CITY OF ALBUQUERQUE

March 29, 2018

RE: **715, 719, 721 14th St NW**
Grading and Drainage Plan
Engineer's Stamp Date: 3/20/18
Drainage File: J13D208

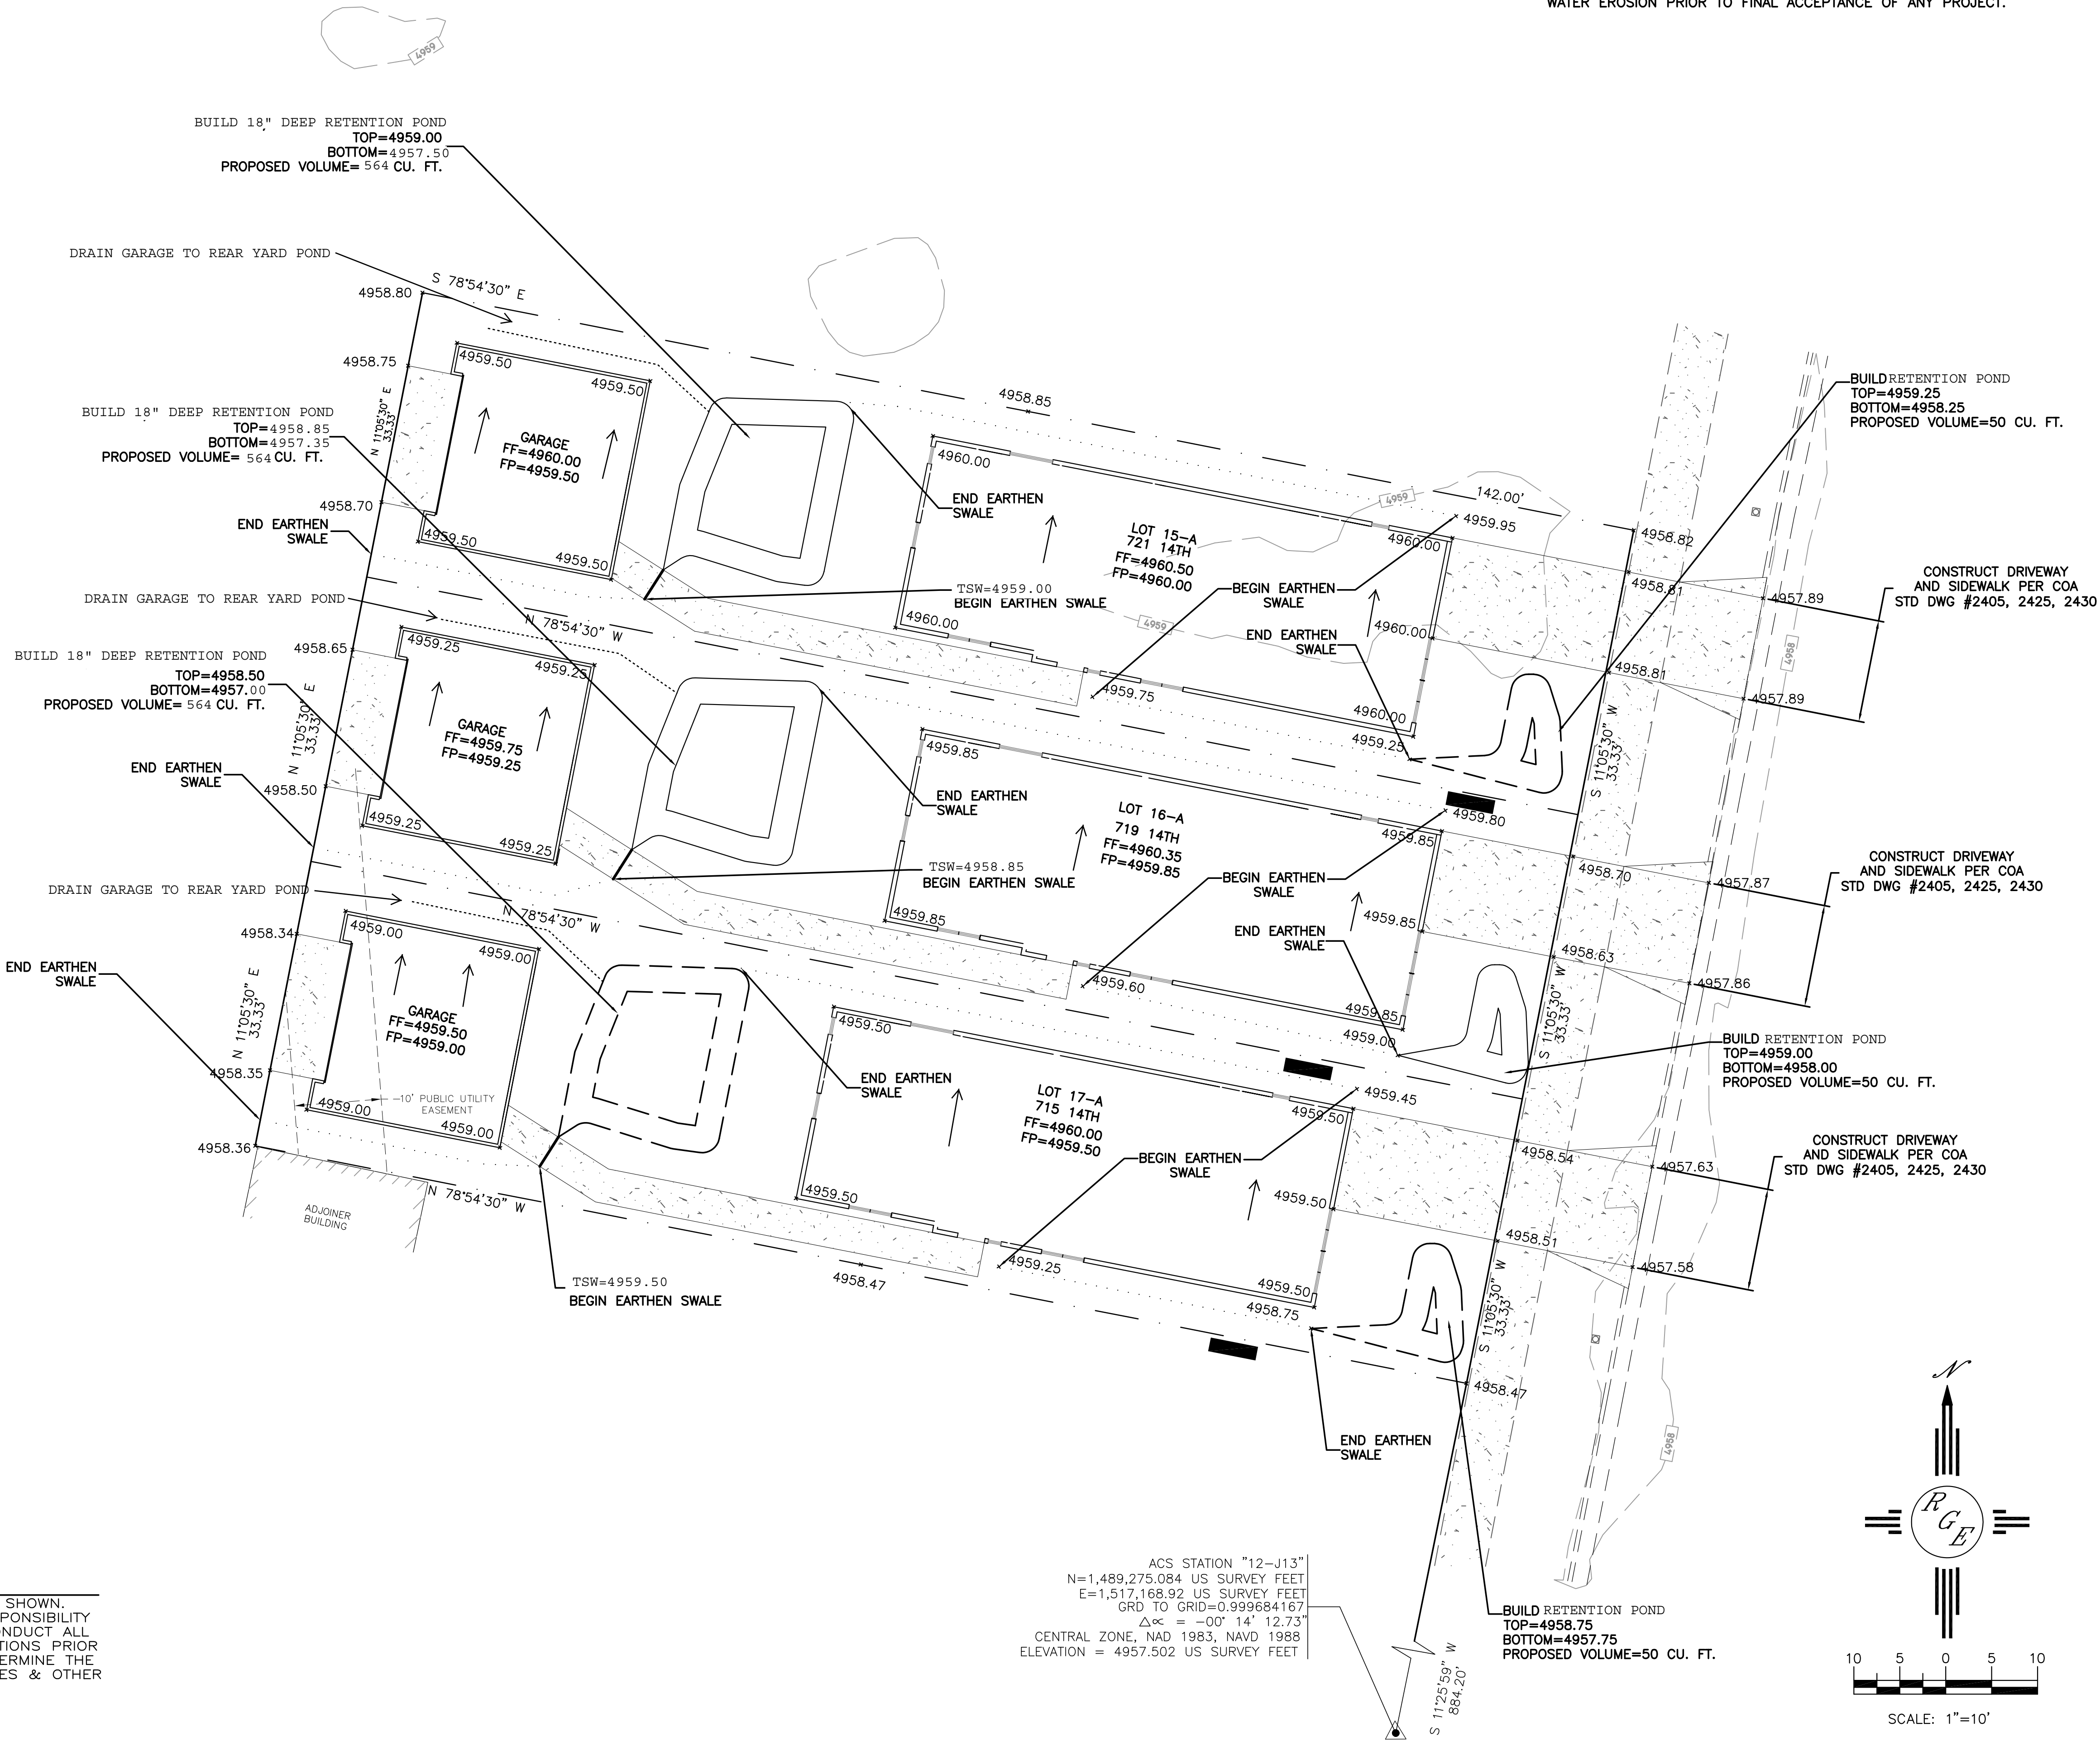
1. Provide onsite ponding volume on each lot for the 100-yr, 6hr volume.
2. Remove the language relating to first flush. Minor residential subdivisions (less than 10 units) and single residences are exempt from the requirement.
3. Provide all calculations on a stamped plan sheet or in a bound and stamped report; loose calculations cannot be accepted.
